July 28, 2020

Re: Falcon Marketplace Final Plat (SF-19-001 CDR-16-007)

Please accept this response letter to comments received April 21, 2020

INTERIM/FINAL
GRADING & EROSION
CONTROL PLAN

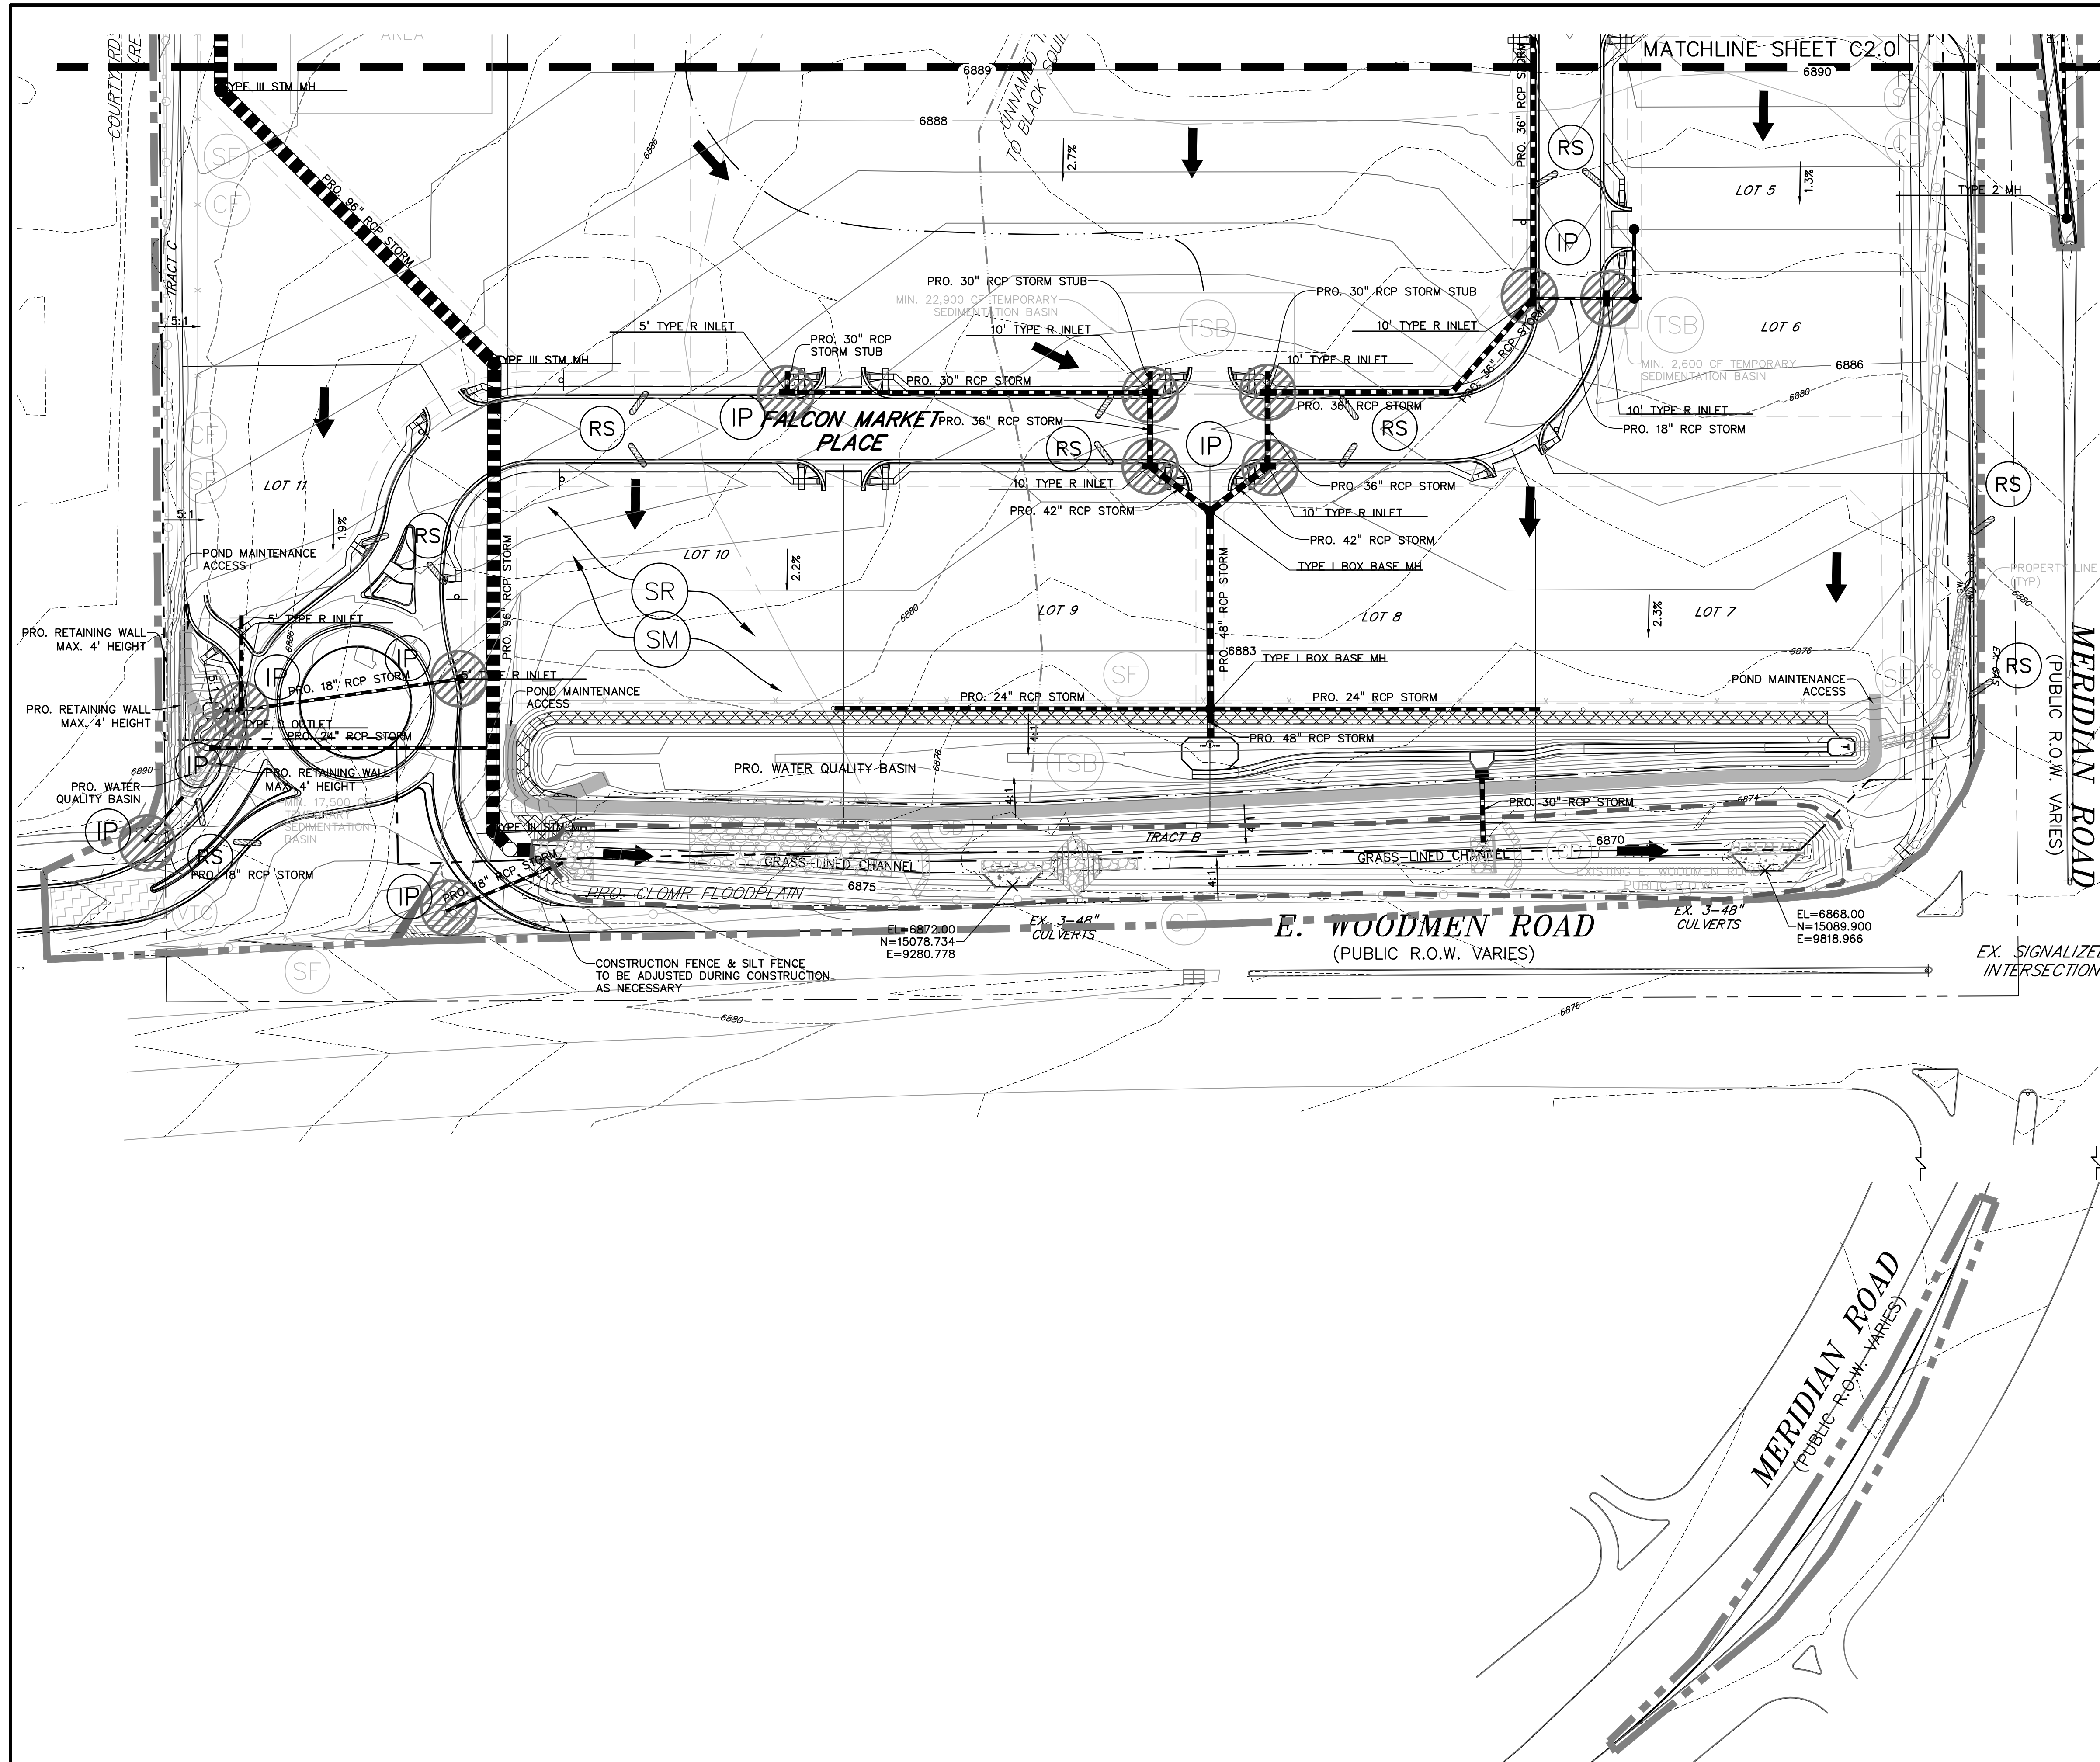
- a. **Items 1i and 1t: Add notes to the GEC plan regarding these items.**
 - b. **Items 1h, 1m, and 1o: Verify offsite construction limits to the north (see redline)**

- c. **Item 1y: If dewatering is anticipated in detention basin or outfall area add notes that these locations may need to be dewatered.**
 - d. **Sheets 2.2, 2.3 from EGP, any additional temporary BMP details, and a notes sheet with the notes below are required.**

- e. **See redlines.**
*GESC plan and checklist revised per notes and redlines. Details and notes sheets included with GESC submittal.***SWMP checklist:**

**SIGNAGE &
STRIPING
PLAN**

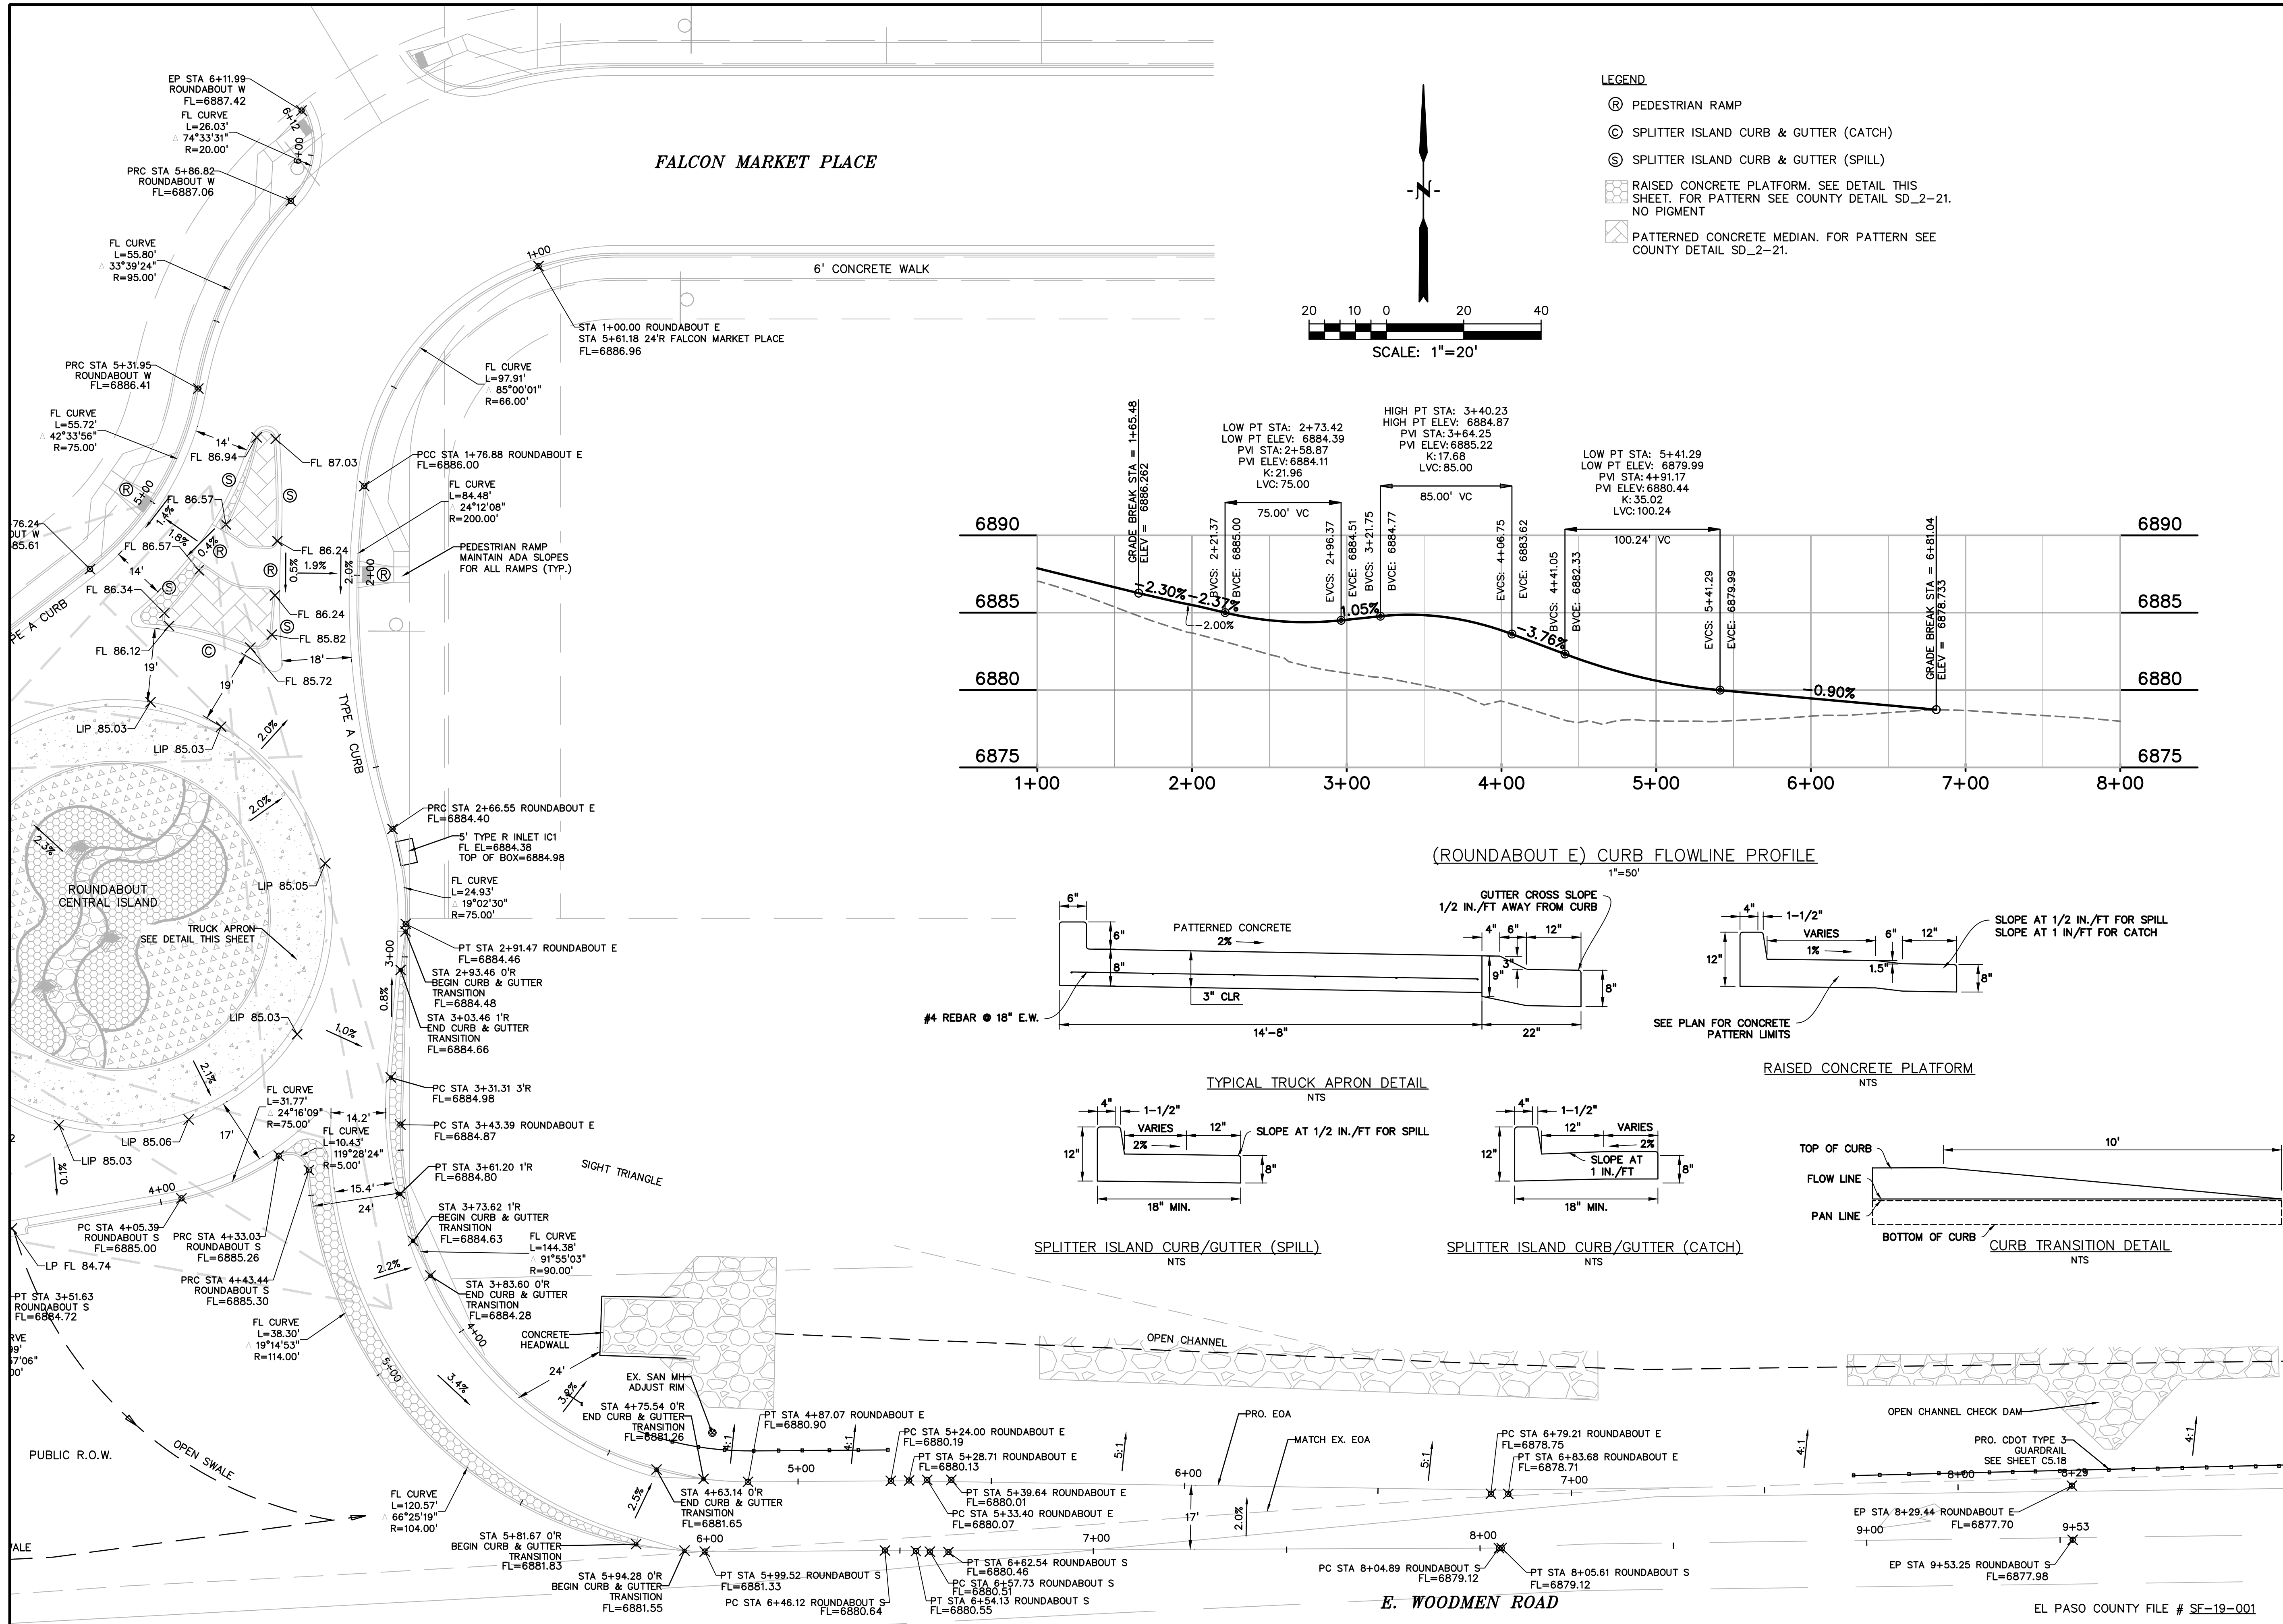
- b. Sheet C5.15 (Meridian Road Striping Plan):
 - i. Resolved.
 - ii. **Resolved.**
 - iii. Provide white channelizing and cross-hatching pavement marking for the northbound left turn lane being consistent with the left turn lane pavement markings for eastbound Woodmen Road at Golden Sage Drive where crossing-hatching lines are spaced at 50-foot intervals and there is a more gradual gore point at the beginning of the turn lane that includes bay entering taper channelization and a longer channelizing line adjacent to the through movement. Also, please add left turn lane arrows, per the MUTCD narrow elongated turn lane arrow design and CDOT S-627-1 Pavement Markings, Sheet 5 mentioned previously. *Partially resolved; verify taper ratio. **Partially resolved; see redlines and correct the taper ratio.** Plans revised per redlines.*

- viii. *Resolved.*
- ix. *Resolved.*
- x. **through xiii – Resolved.**
- xiv. Provide Keep Right signing on Meridian Road with placement and panel face orientation consistent with MUTCD Figure 2B-17. ONE WAY Signing for Divided Highways with Median Widths Narrower Than 30 Feet and Separated Left-Turn Lanes. *Unresolved. **Unresolved (not found).** One-way signage shown on sheet C5.15. Keep right signage on Meridian islands shown on sheet C5.16*

- xv. Provide MUTCD Advance Street Name Signs (D3-2) on Meridian Road, consistent with other Meridian Road signalized intersections. Provide advance street name sign panel design and layout details in the project plan sheets for sign fabrication, consistent with MUTCD standard panel sizing and FHWA Standard Highway Signs, 2012 Supplement sign design information. Reference the appropriate CDOT Standard Plan detail sheets for sign support information. **Unresolved. (Response is that this is still under review)** Advance street name signage added to sheet C5.15 and C5.16.
